Recommendation Report for Planning Permission for Works or Extension to a Dwelling

REF NO: LU/351/20/HH

LOCATION: 17 Peregrine Road
Littlehampton
BN17 6DT

PROPOSAL: Erection of a new garage

Project:	
Proposed garage; 17 Peregrine Road, Littlehampton BN17 6DT	
Drawing:	
Plans and elevations as proposed	
For:	
Mr. & Mrs. C. Weightman	
Drawn:	Date:
PKS	December 2020
Scales:	No:
1:50 1:100 1:500	2681/01/01
To scale when printed on A3

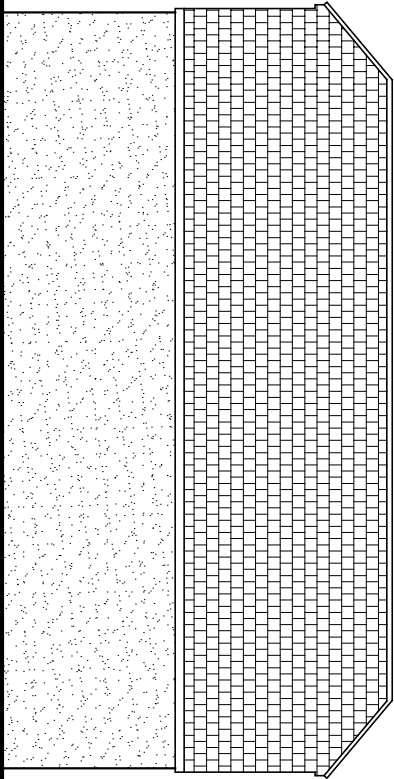
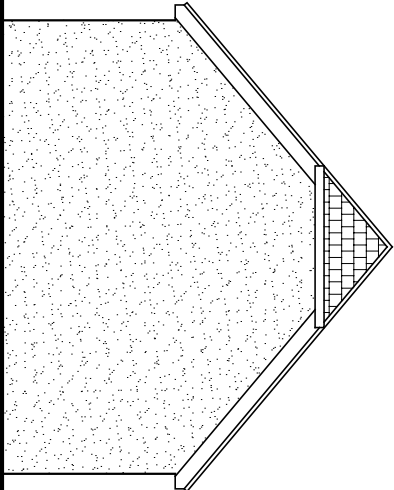
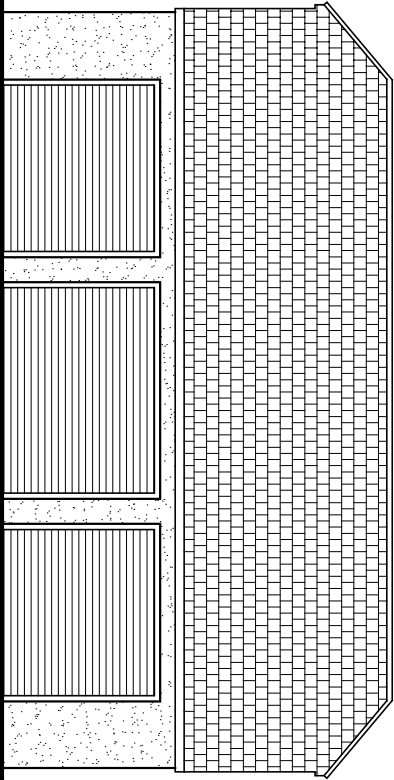
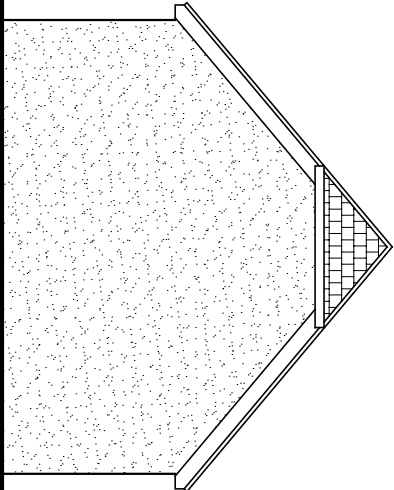
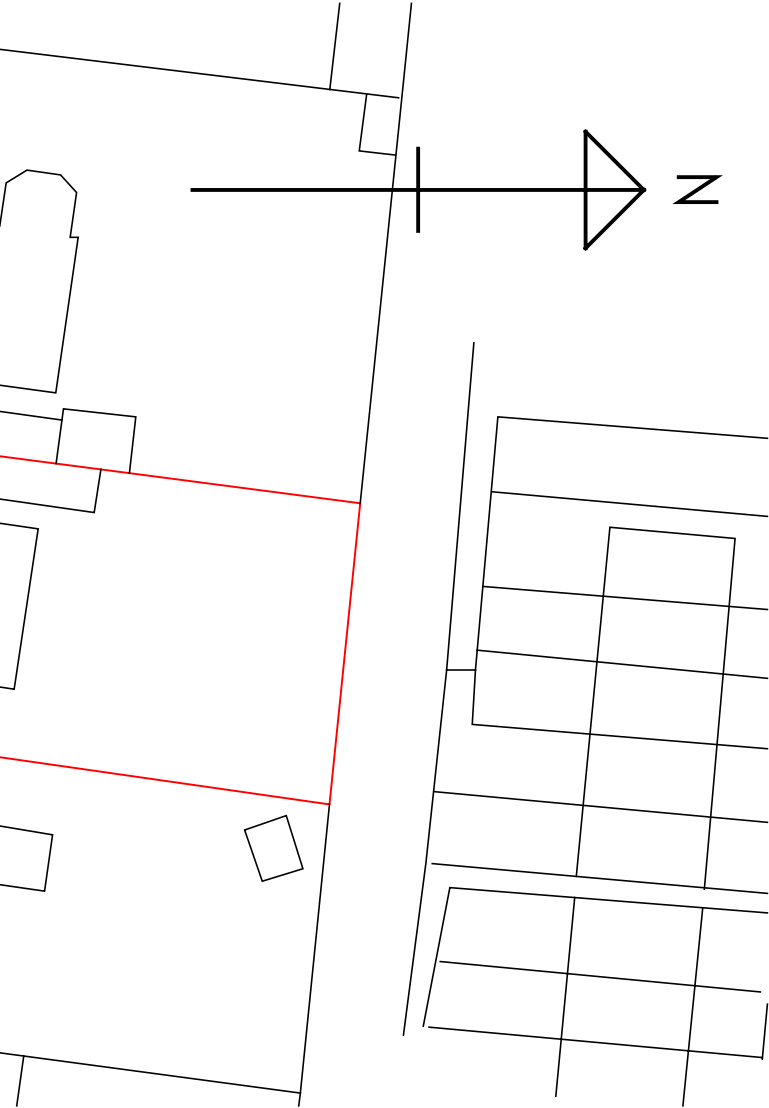
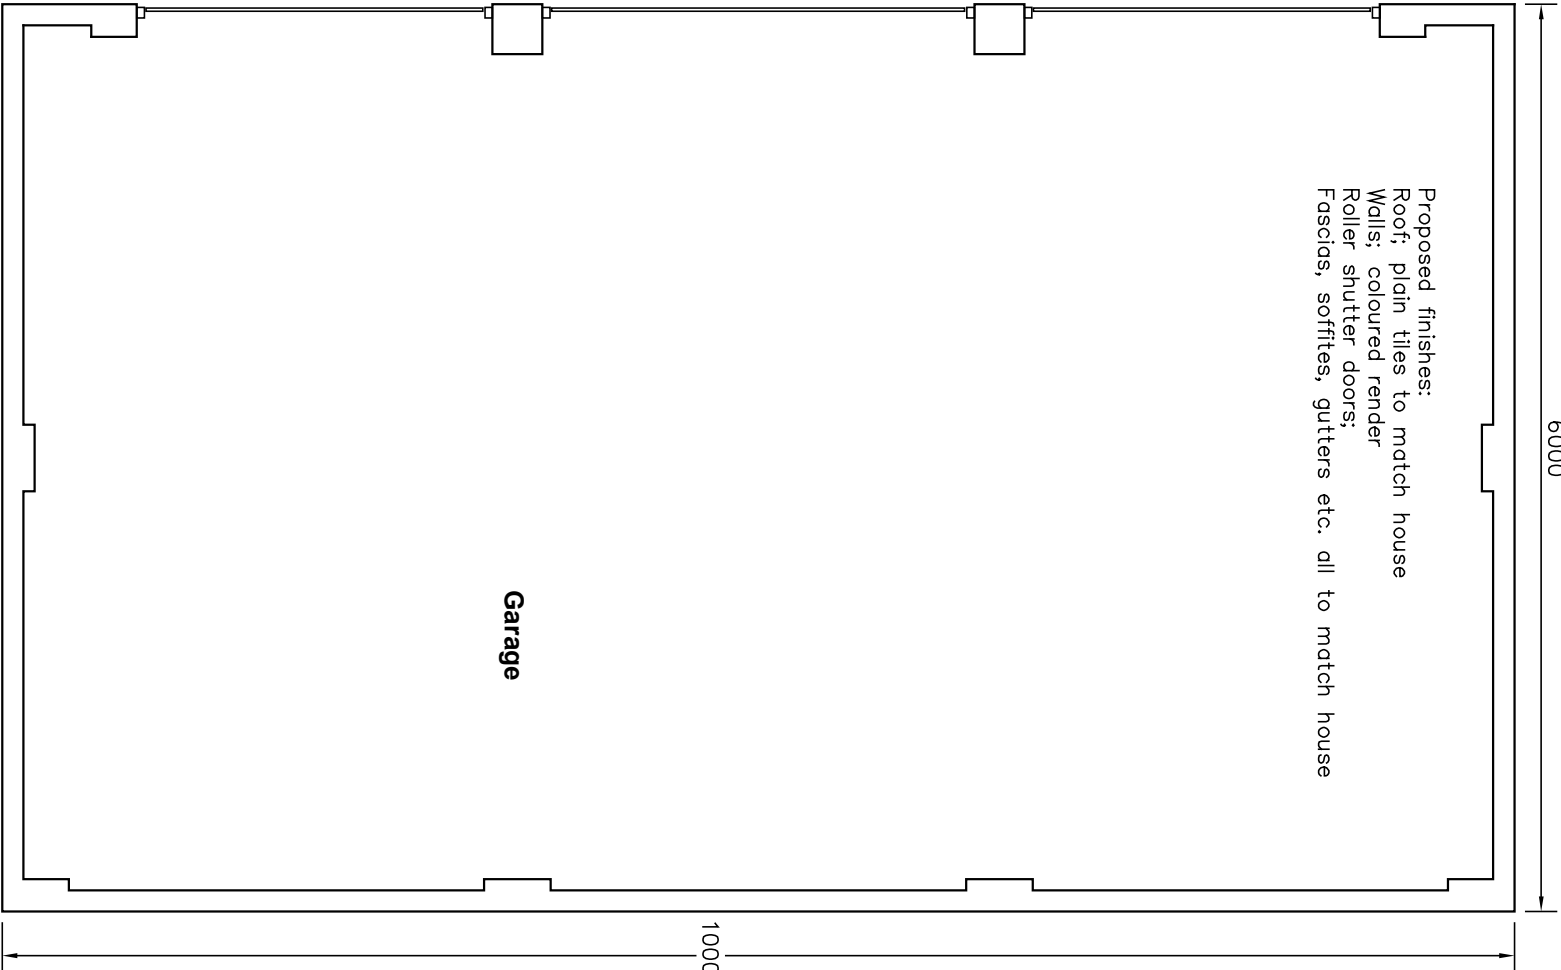
Due to the siting of the proposed garage, there will be some available views of the proposed garage from within the public realm. The proposal is sited within the front garden of the host dwelling and measures 10m in length, 6m in width and a maximum height of 5m. As such, the proposed garage has a similar footprint to that of the host dwelling, however, sited towards the front of the application site.

The proposed garage is considered to have a detrimentally harmful impact upon the character of the locality through the introduction of a large, bulky garage within the front garden of the host dwelling, which is at odds with the locality. Whilst it is noted that the boundary foliage present at the site may screen some views of the proposed garage, there will be views from the East and West of the long, 10m roof line present, which alone is considered to have a significantly harmful impact. This is because whilst the hedge screens approximately 3m of the garage, the remaining 2.1m will remain visible within the street scene for a length of 10m. There will also be a gap in the screening at the front where the majority of the garage will be visible.

Whilst it is noted that there is screening present bordering the site, as explained above, it is not considered to be significant enough to mitigate the harm of the unduly large garage proposed. The proposal is not considered to respond to the constraints of the site or the area. The application conflicts with policy D DM1 of the Arun Local Plan, and J.01 of the Arun Design Guide which relates to the context of the area being taken into account to the design and identity of proposals.

- 1 The appearance of the proposed building has a significantly harmful impact upon the character of the street scene, and the wider locality, due to its height, scale and siting. The proposal conflicts with Policy D DM1 of the Arun Local Plan and the Arun Design Guide.
